January 3, 2013

**RE: Response to City Review Comments
Level I Site Plan Development Review Application
Motley Street Extension, Portland, Maine**

**C3.0**

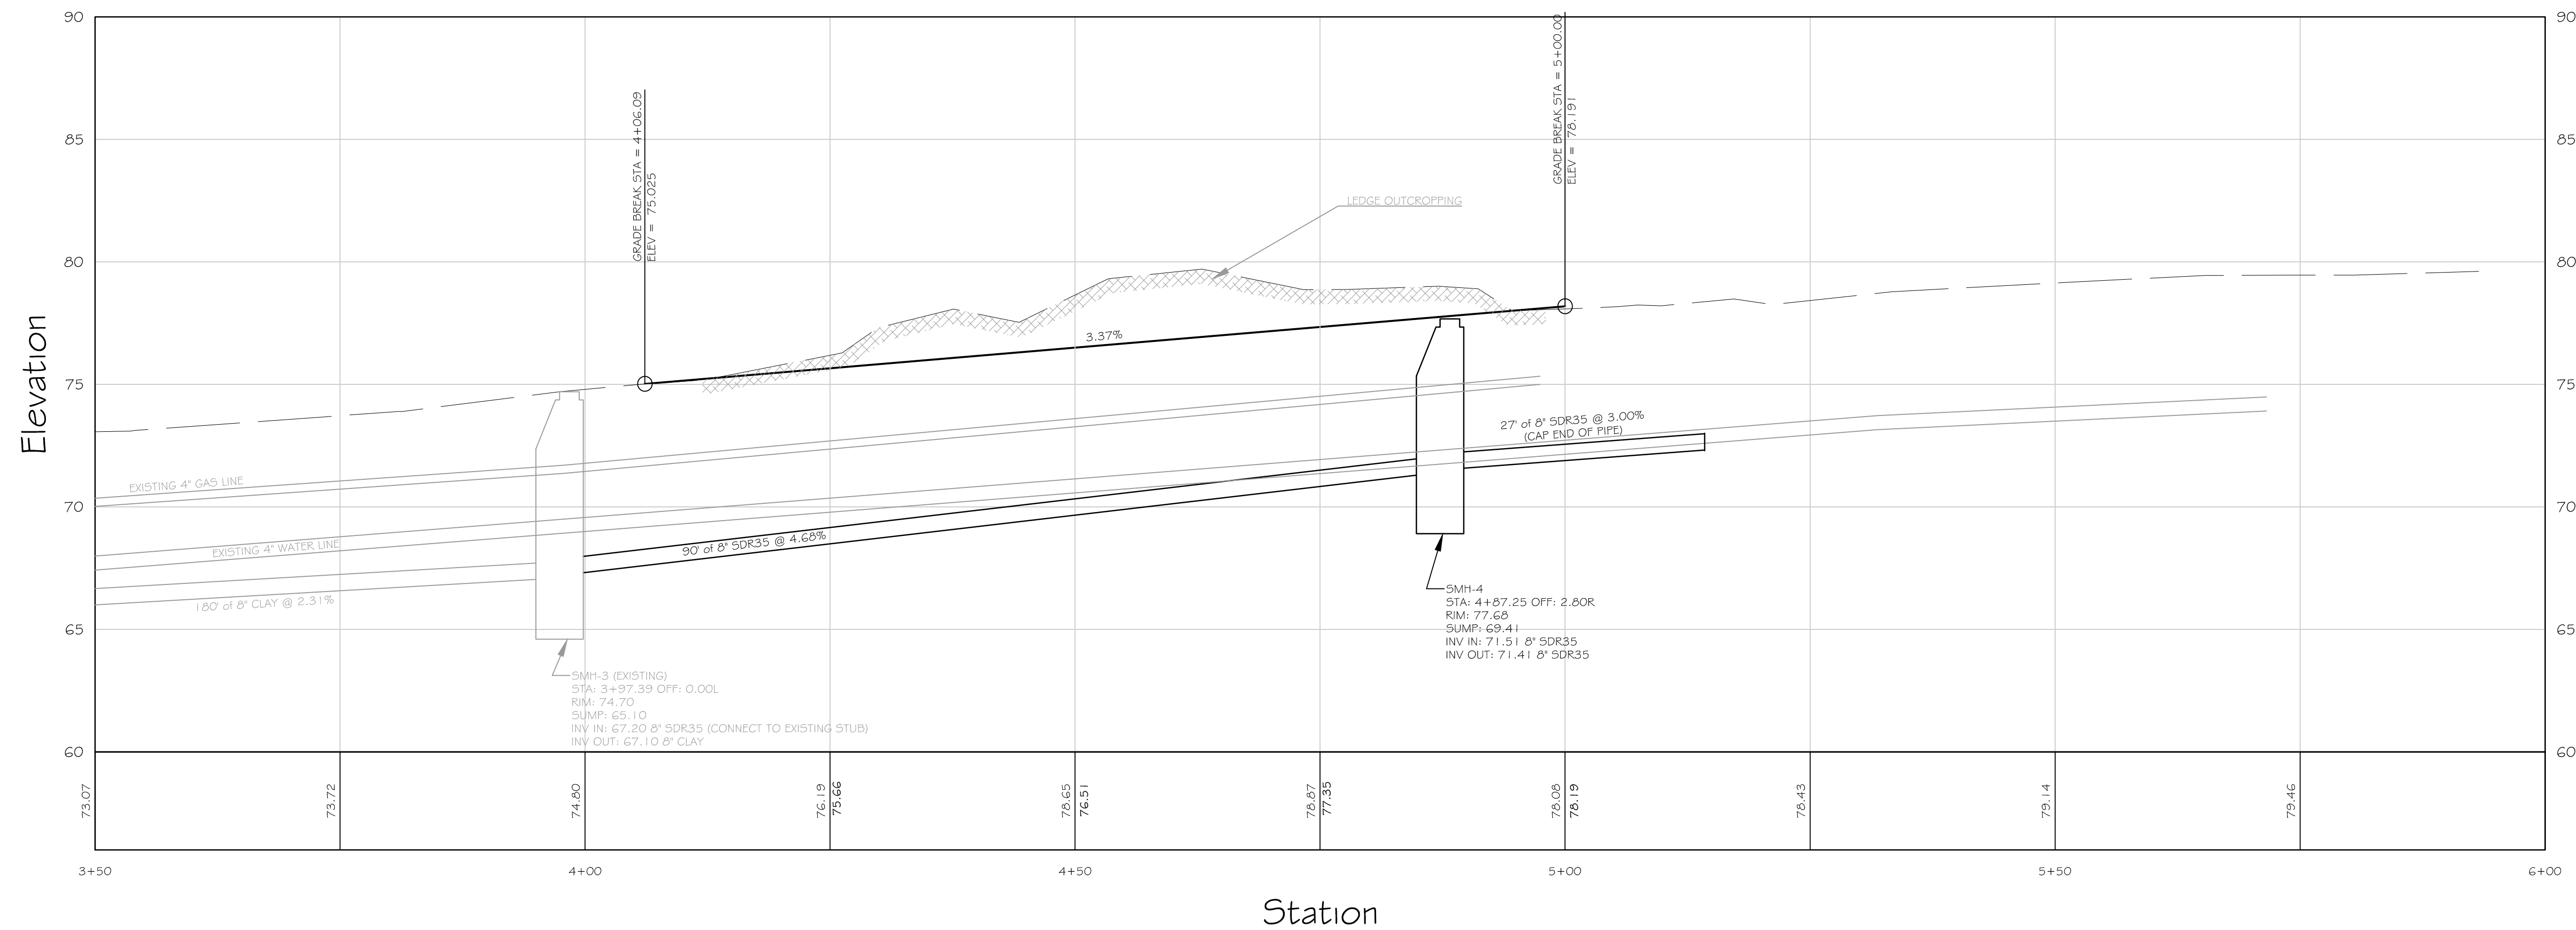
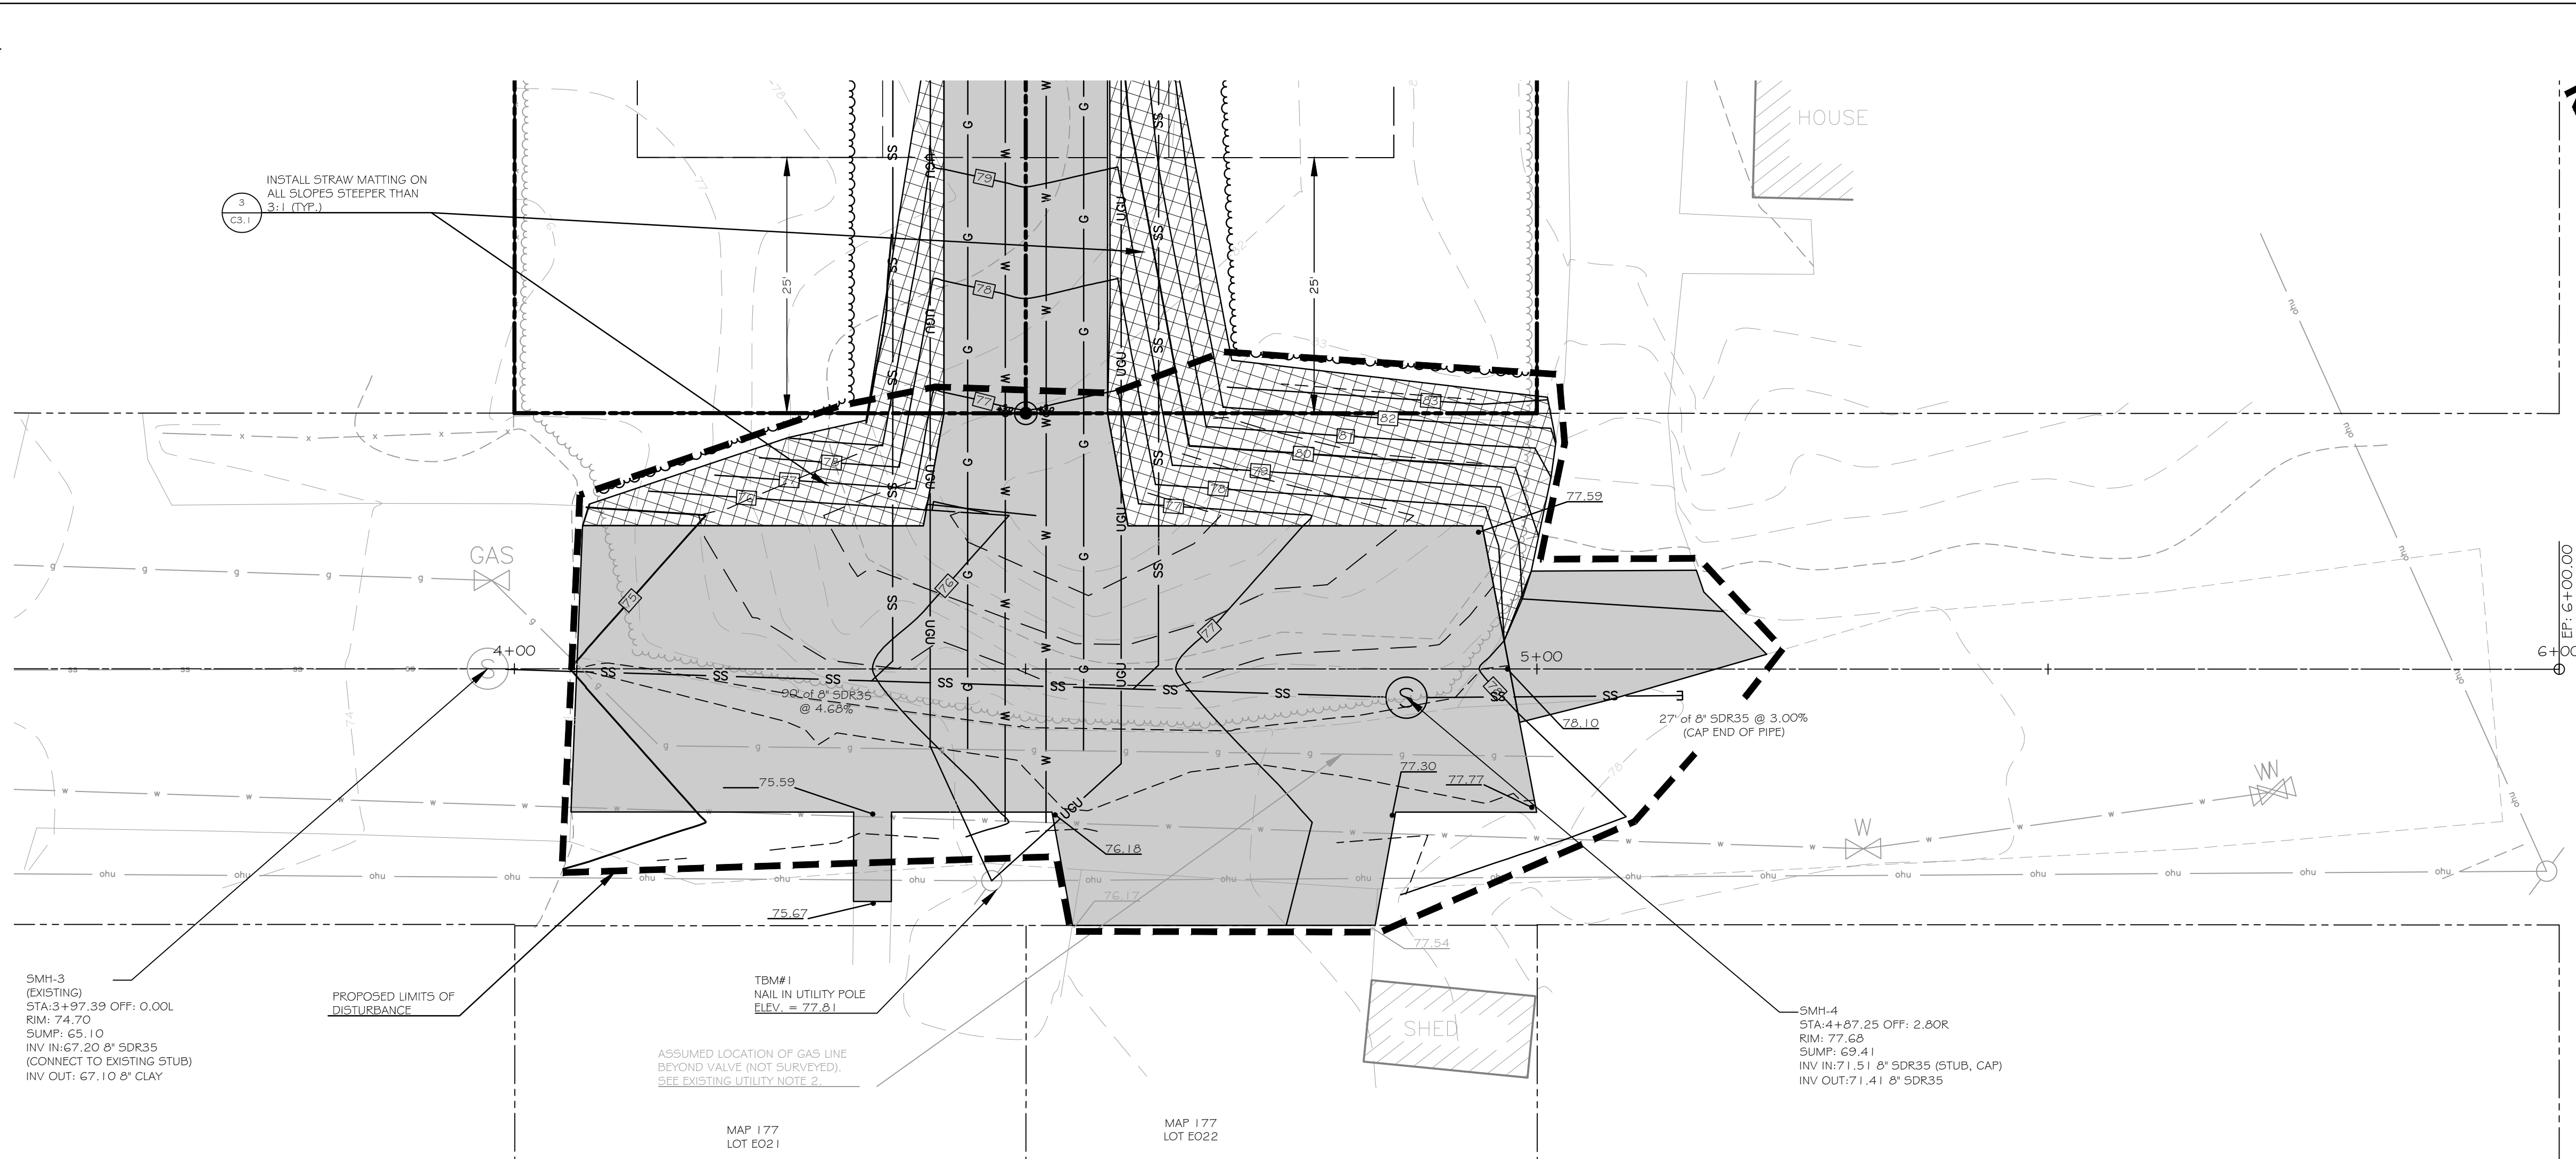
Walsh Engineering Associates, Inc. has reviewed section 3.7 of the City's Technical Manual and has added a note to sheets C.2.0, C2.1, and C3.0 that a blasting permit and all associated submittals will be required for a "large blast" operation (removal of greater than 300 c.y. of rock material).
